Application no: 23/01493/REM

Location: Proposed Himley Village North West Bicester, Middleton Stoney Road, Bicester

Transport Schedule

OS NORTH

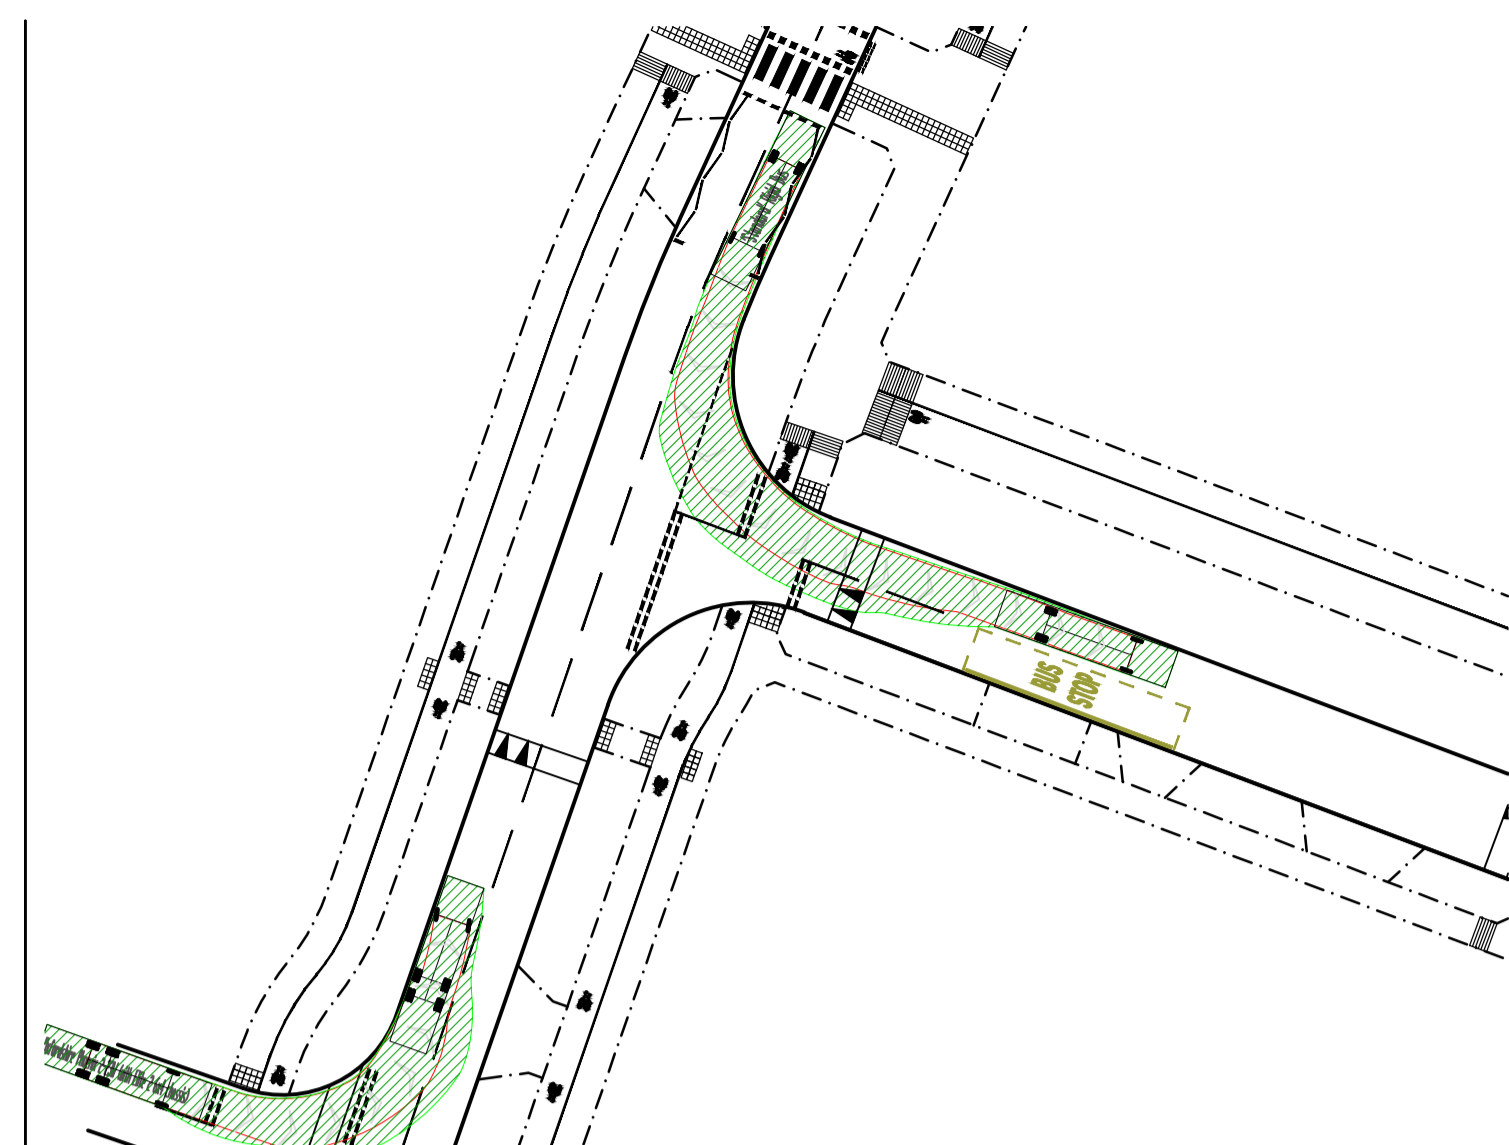
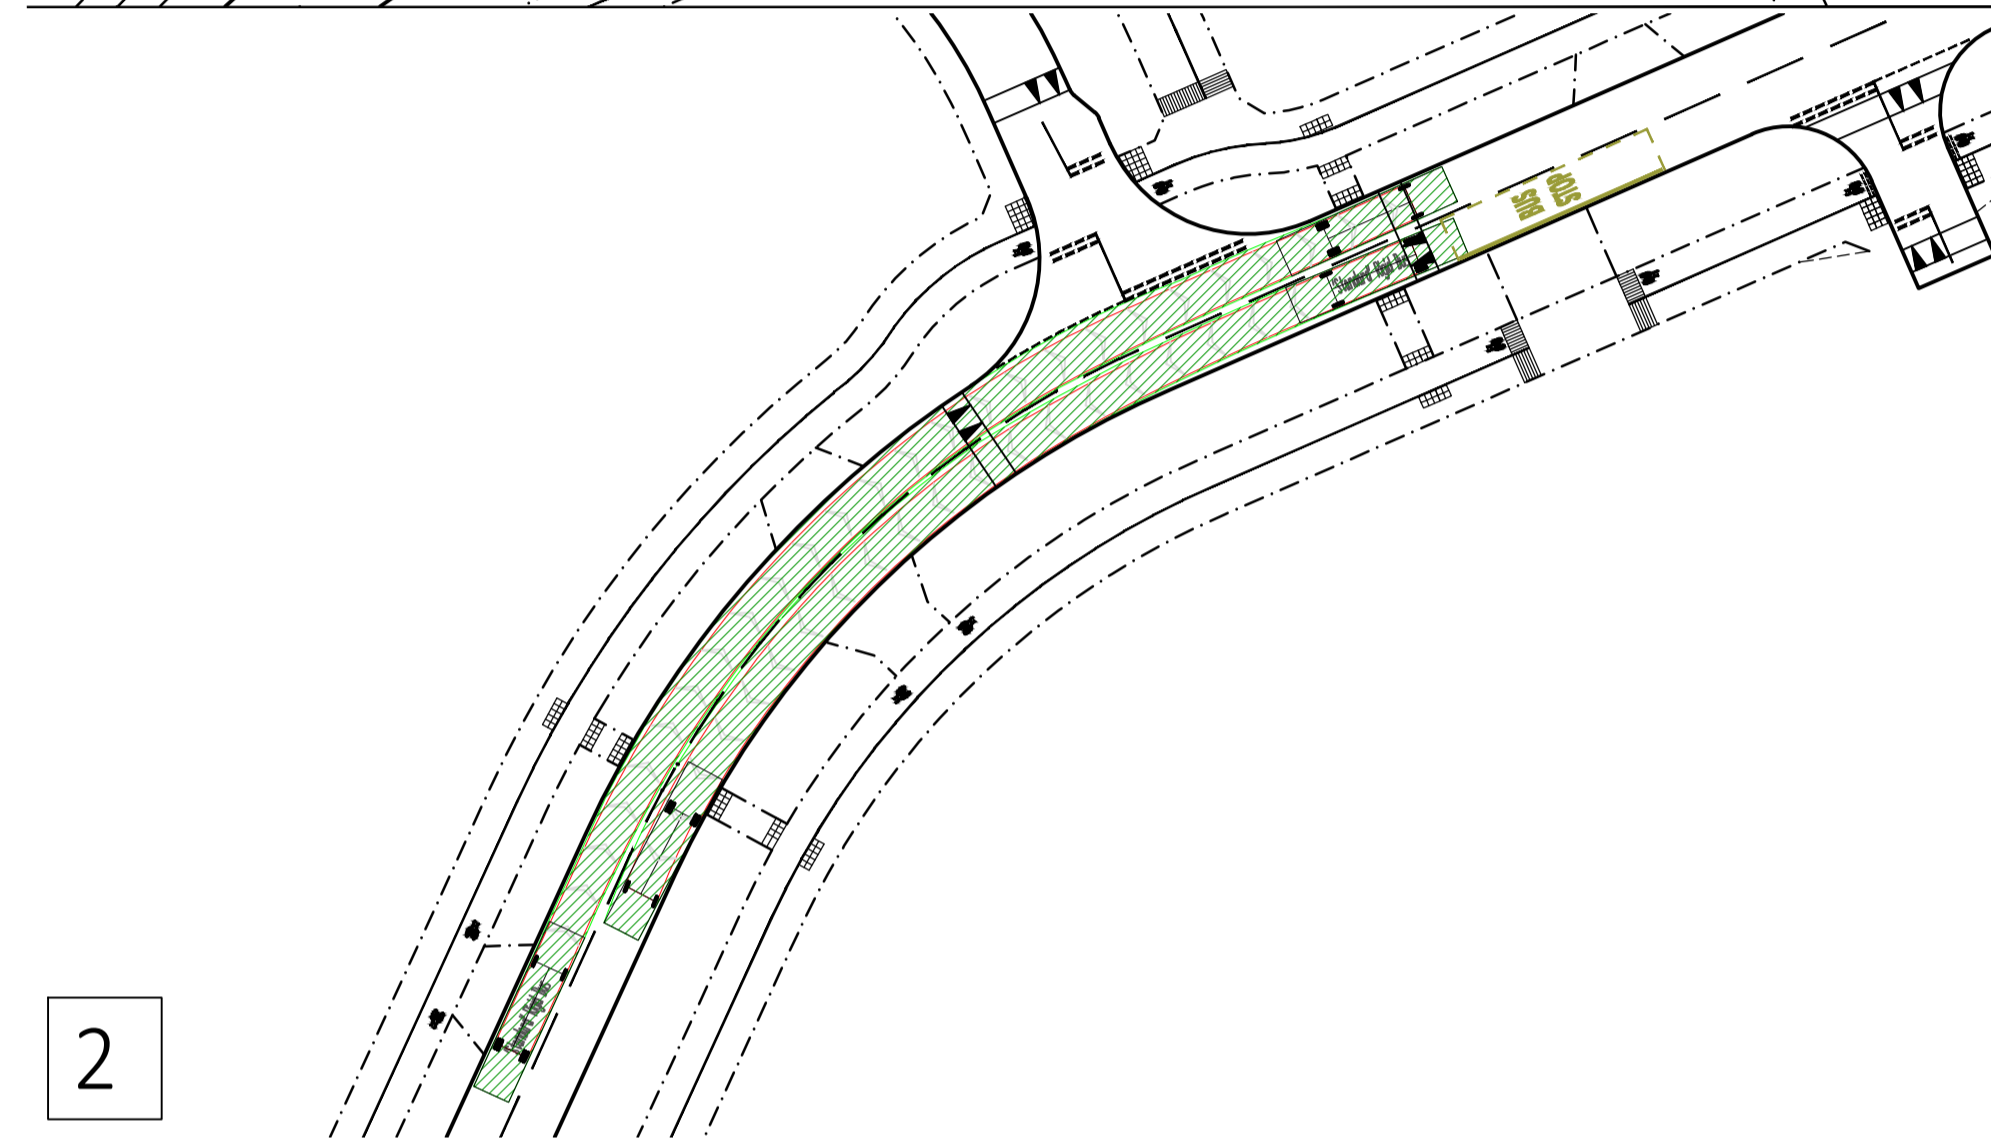
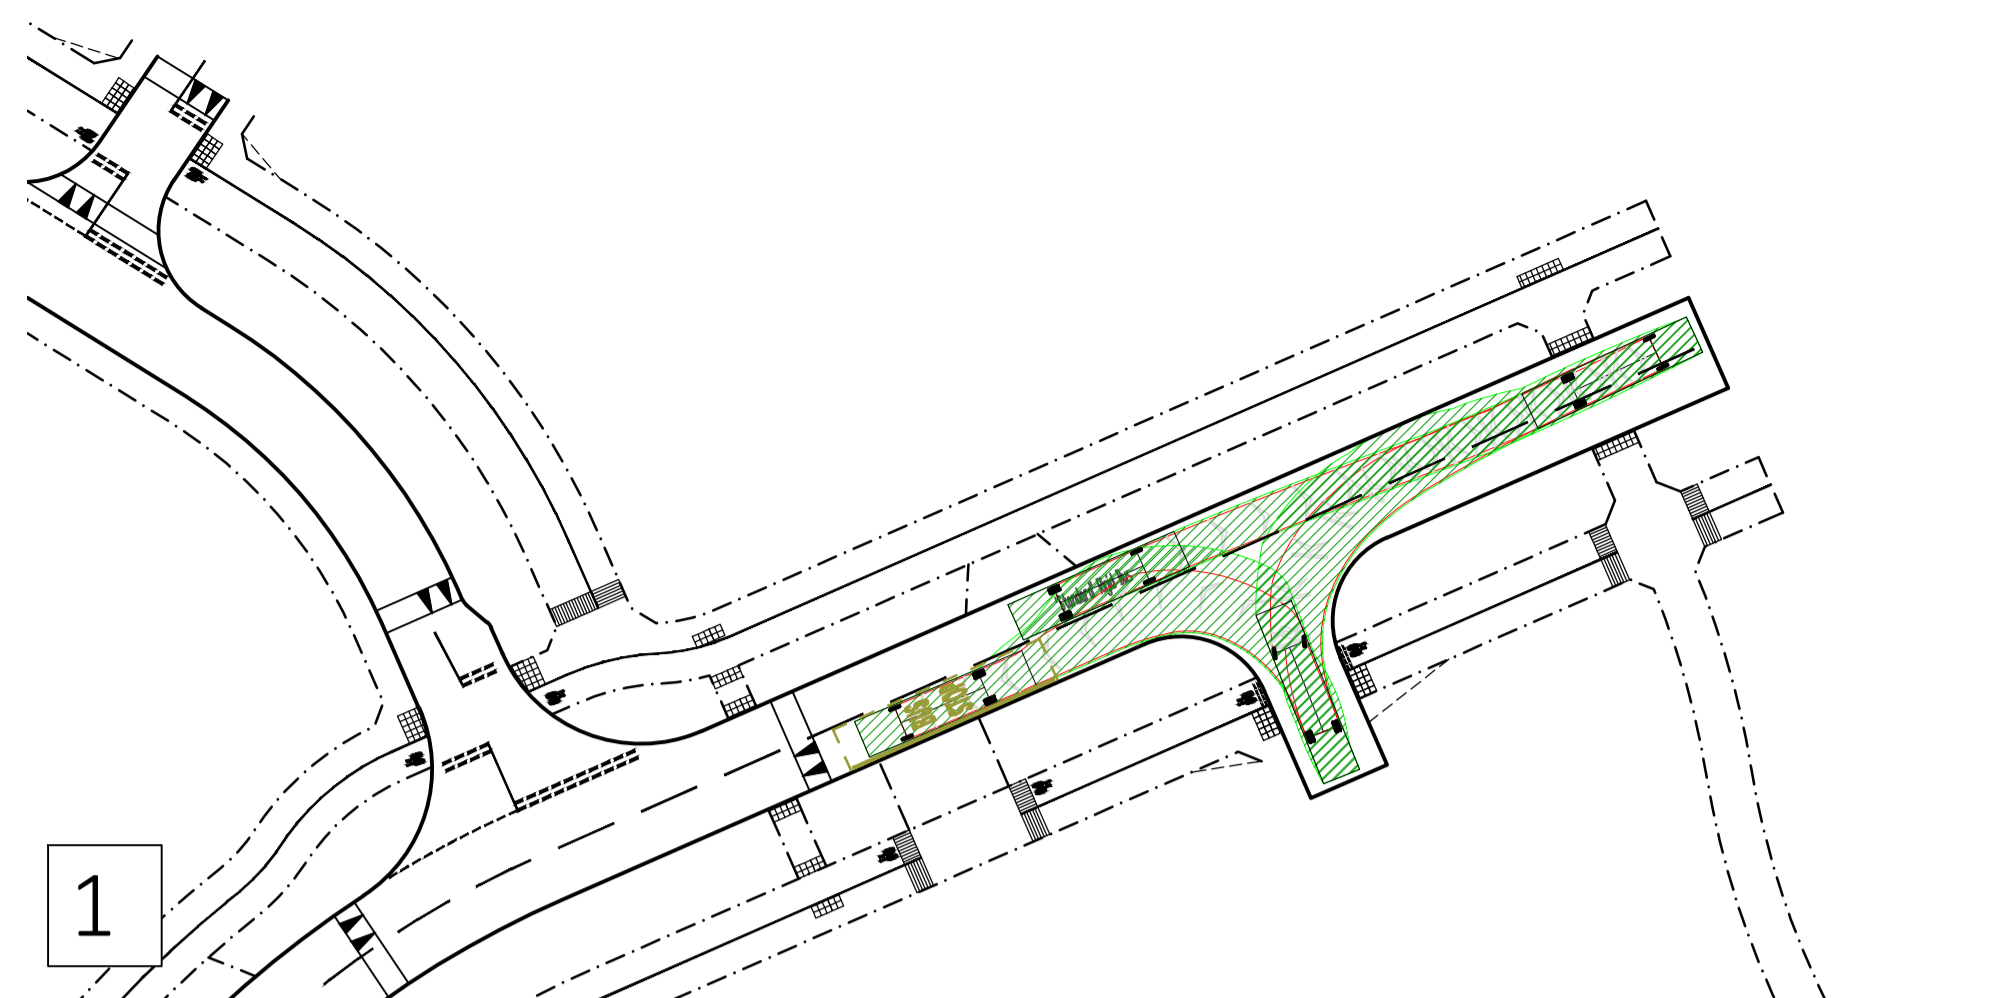
I previously explained that the temporary bus turning heads were not acceptable as it would require buses reversing over the raised cycle crossings. After discussions with the applicant, it has been agreed that the raised cycle crossings at the northern end of the Spine Road North - South and at the eastern end of the Spine Road East - West will be implemented when Oxfordshire County Council have confirmed that the requirement for the use of the temporary bus turning heads has ceased.

In addition, the raised crossings at the western end of the strategic secondary streets will be implemented when these roads connect to Phase 3 and Oxfordshire County Council have confirmed that the temporary turning heads are no longer required. Insets on the Engineering Layout Sheets 1 to 4 include the layout of all the temporary turning head as well as the agreed final layout.

A condition to this effect has been included.
